Online Comment

Application H06-1108-22
Location Land North & South of Main Road and East of Dawsmere Road Gedney Drove End
Proposal Proposed temporary met mast up to 140m high to gather a range of meteorological data during c. 18 month period as part of overall feasibility assessment for the electrolysis, wind and PV at Jepco including the repowering of Red House Wind Farm

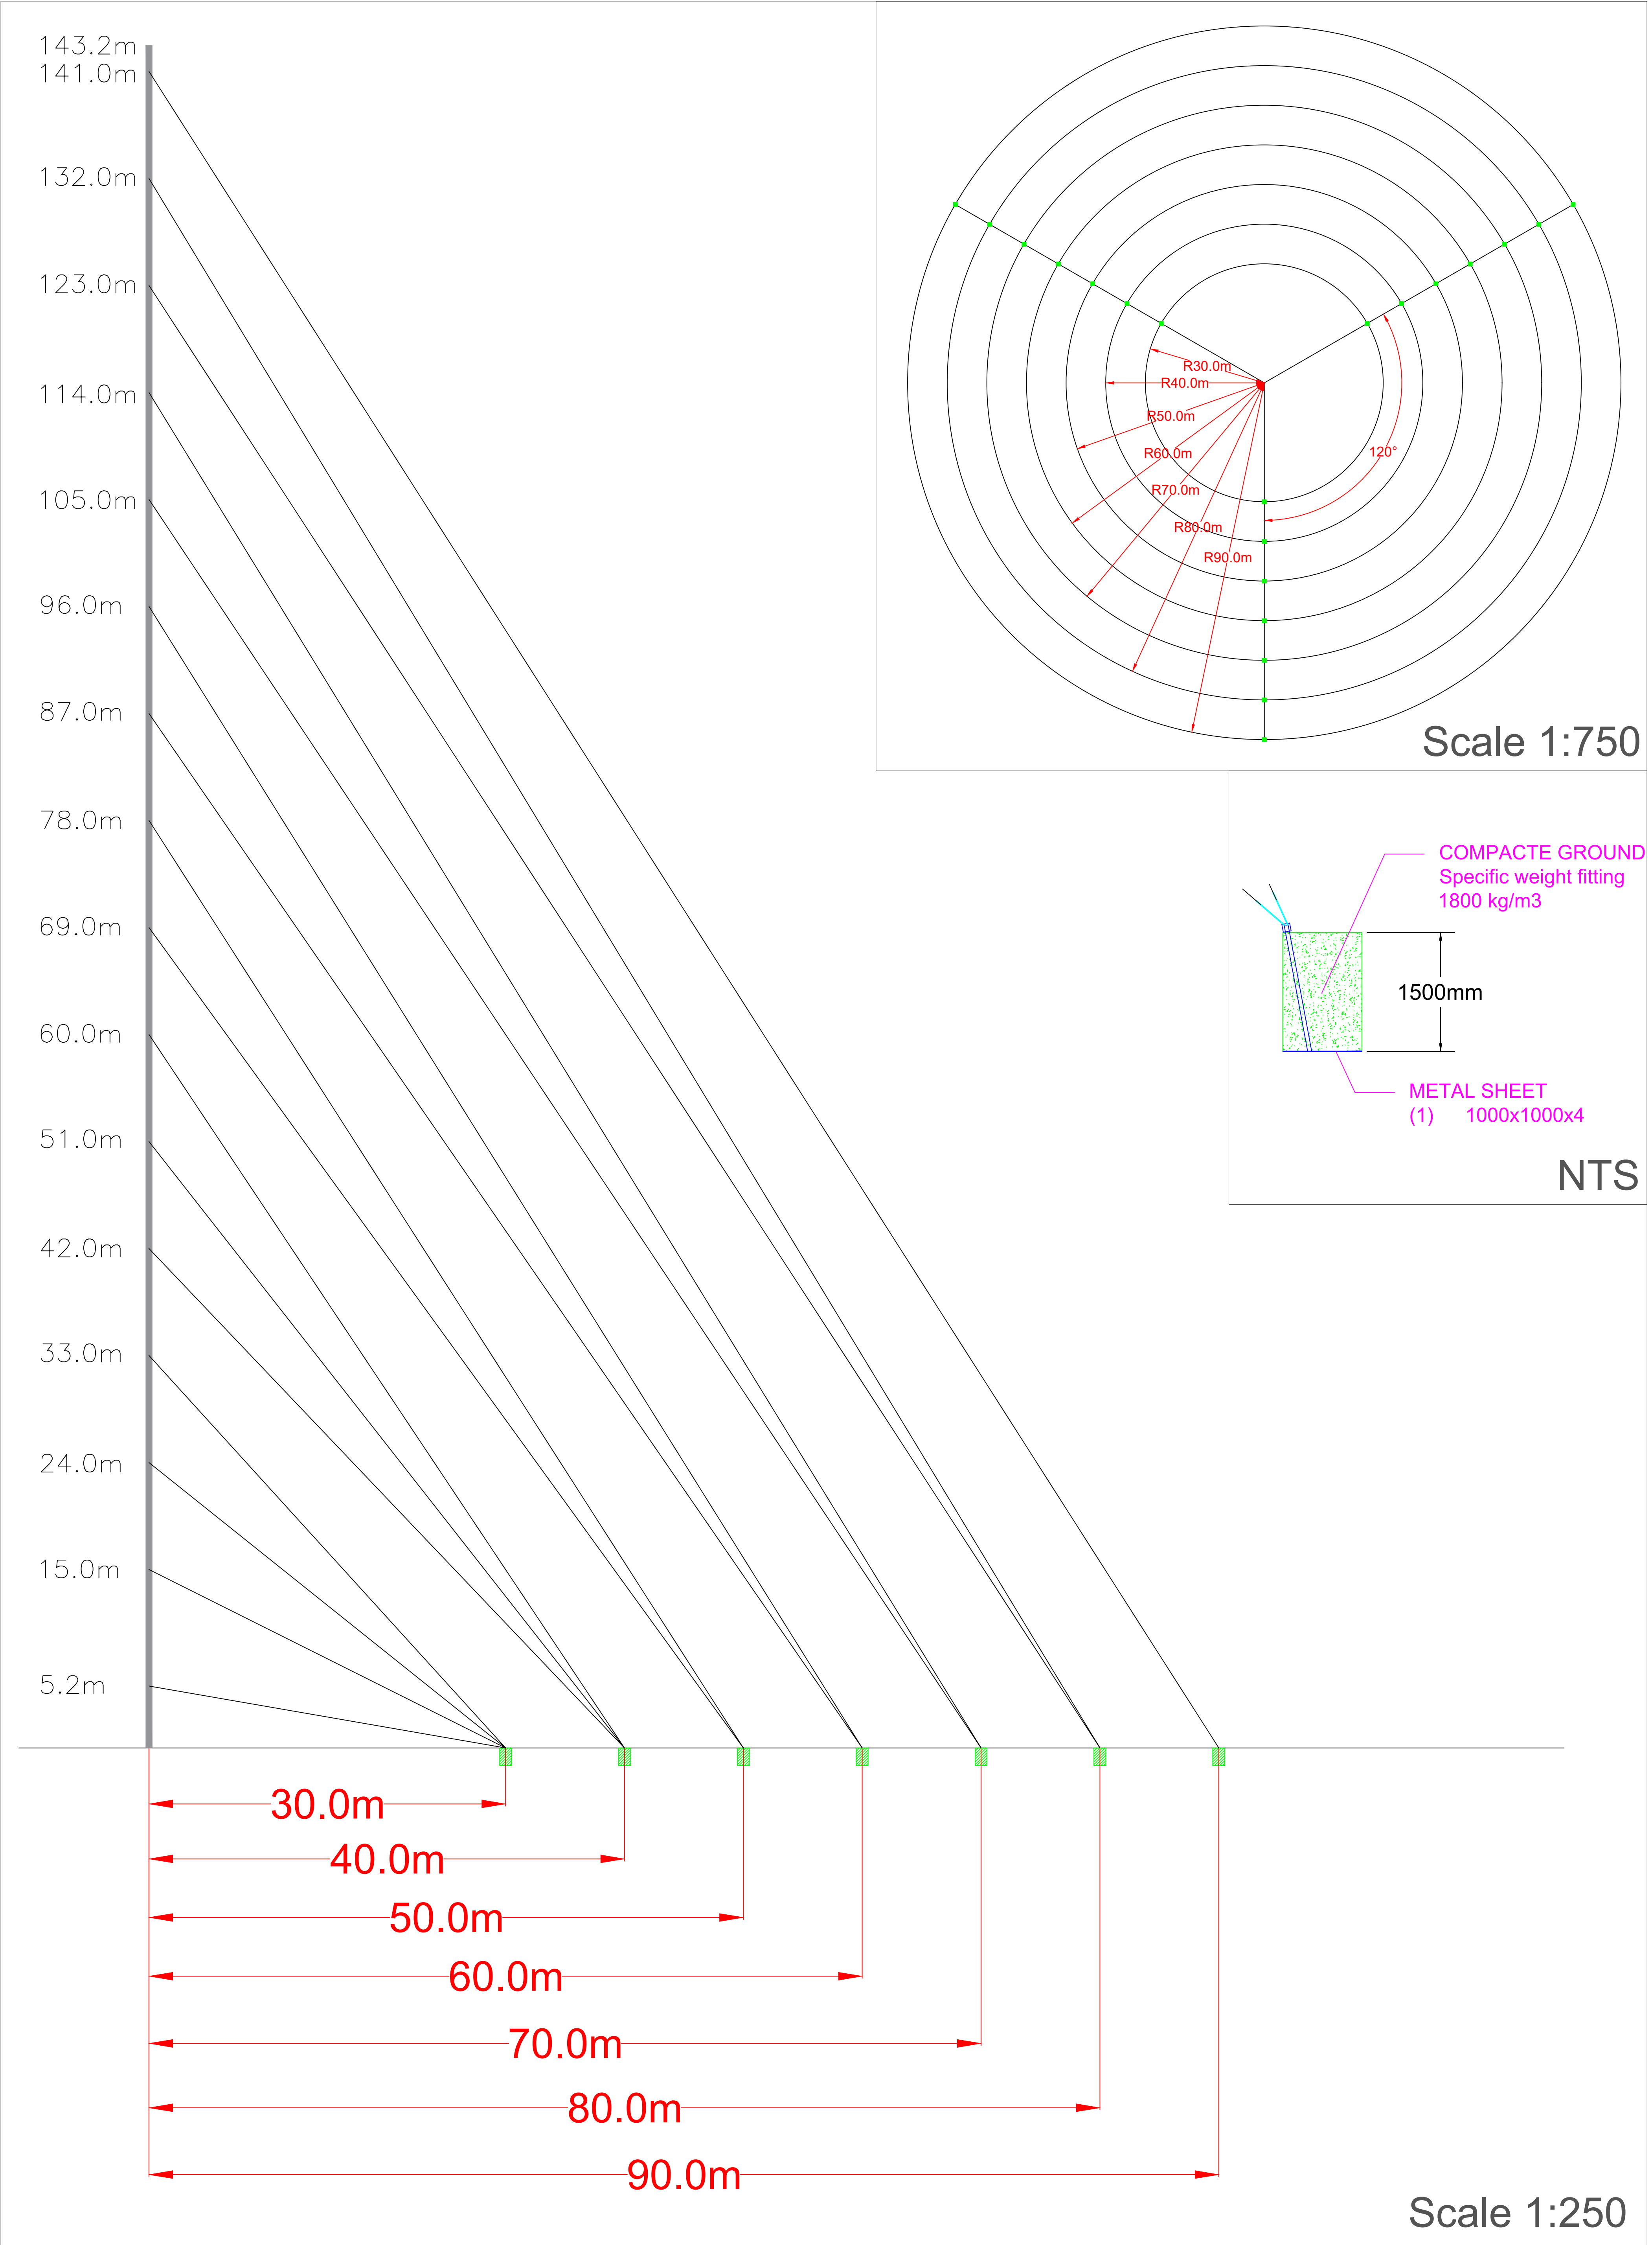
RSPB have previously commented (in 2009) on proposals for a similar mast. We would advocate reflectors or similar to be attached to the guy wires to make them more visible to birds in flight, especially when light or weather conditions are poor. Significant numbers of birds (principally pink footed geese and waders such as golden plover use the Wash and surrounding farmland and chance of strikes increase when cropping is predominated by sugar beet and or open ground. We recommend walk over surveys are conducted to search for presence or absence of bird corpses. These data would help inform future planning applications and give greater levels of confidence the proposals would impact on protected species.
